**Engineers Comments Regarding Surface Water Drainage**

**Application No:** WA/69/20/DOC

**Site Address:** Murroes Dairy Lane Walberton BN18 0PT

**Description of Works:** Approval of details reserved by condition imposed under ref WA/36/20/HH relating to Condition No 3 - surface water drainage.

© This drawing is the copyright of Robert Clark Associates Limited It may not be copied or reproduced without their written authority			
Scale Not to Scale		At original A3	
Drawing Number 2039/SK6		Revision -

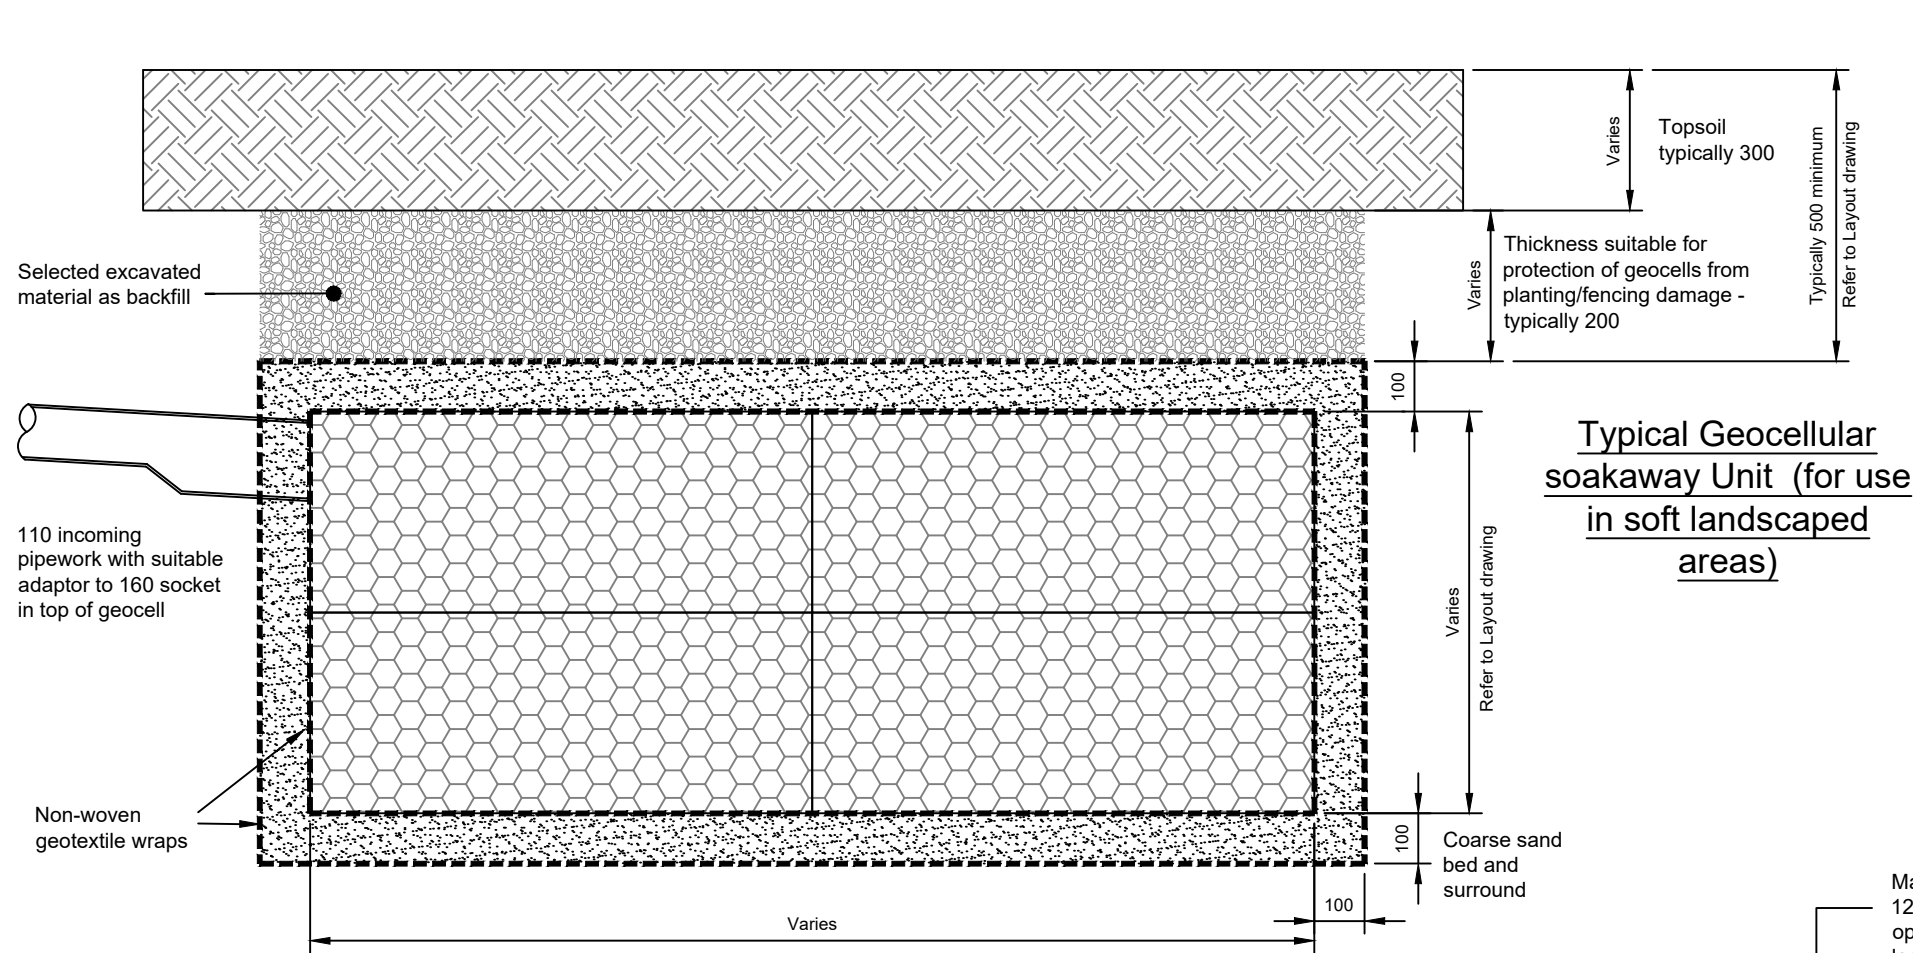
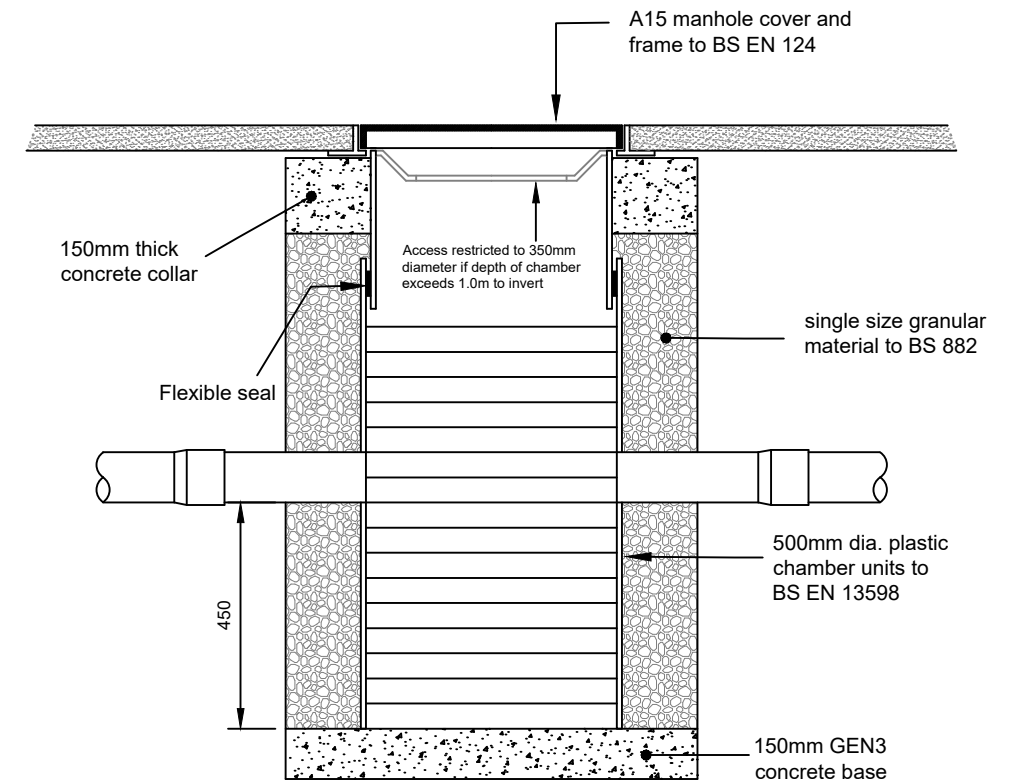
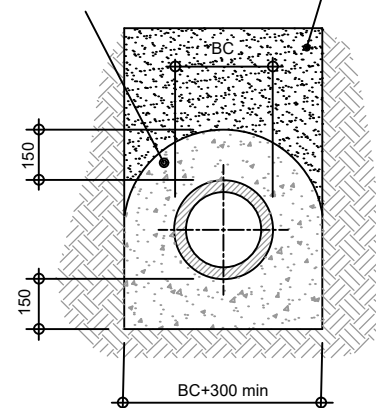
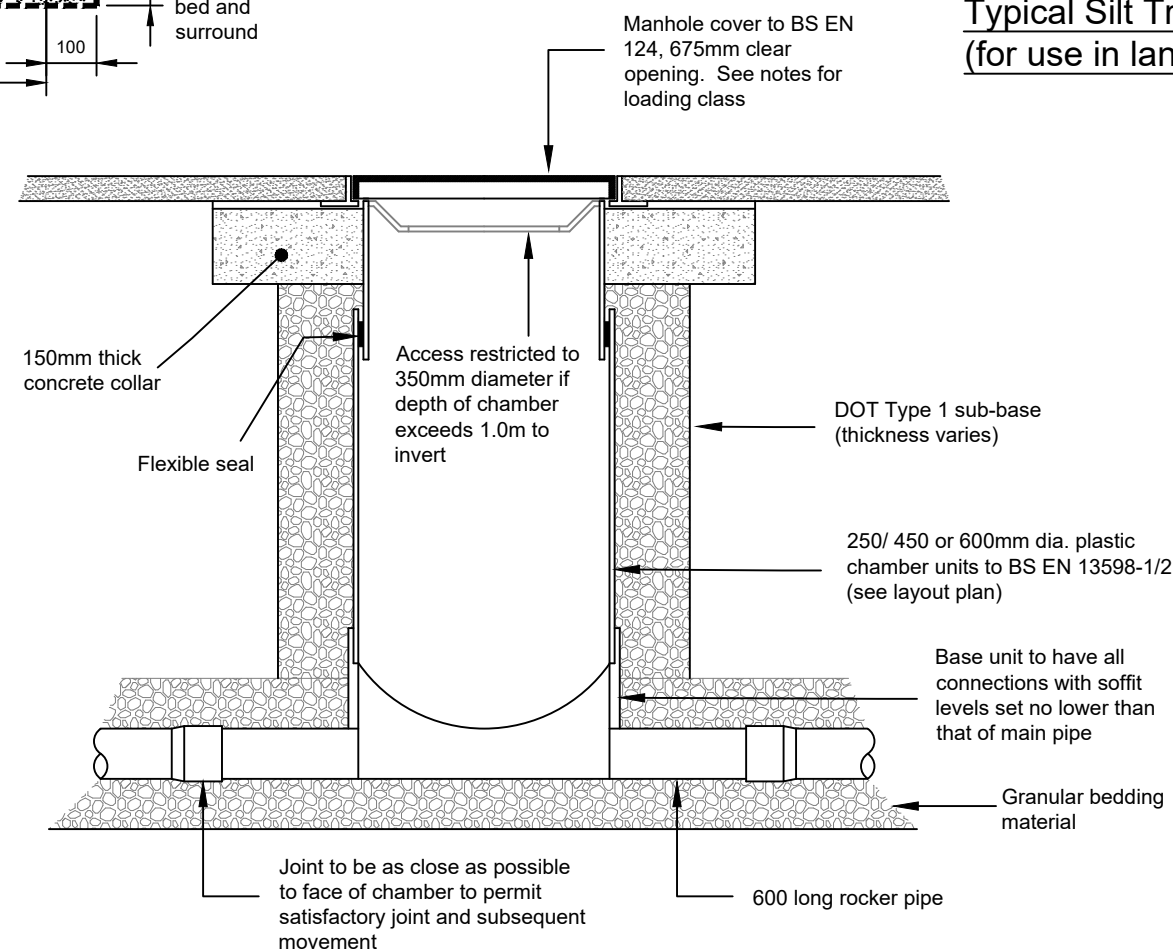
It is recommended that Condition 3 imposed under ref WA/36/20/HH is discharged. Surface water drainage to be constructed in accordance with 'Surface Water Drainage Dwg No 2039/SK1' and 'Construction Details Dwg No 2039/SK6'.

Note; recommendation is based upon winter groundwater monitoring and percolation testing at the neighbouring property Scafell. Publicly viewable in application WA/16/17/DOC. Percolation testing completed in September evidences that conditions are not worse in this period, allowing the neighbouring results to be used for the calculations. This recommendation is not be read as an acceptance of percolation testing and groundwater monitoring completed outside of the winter period.
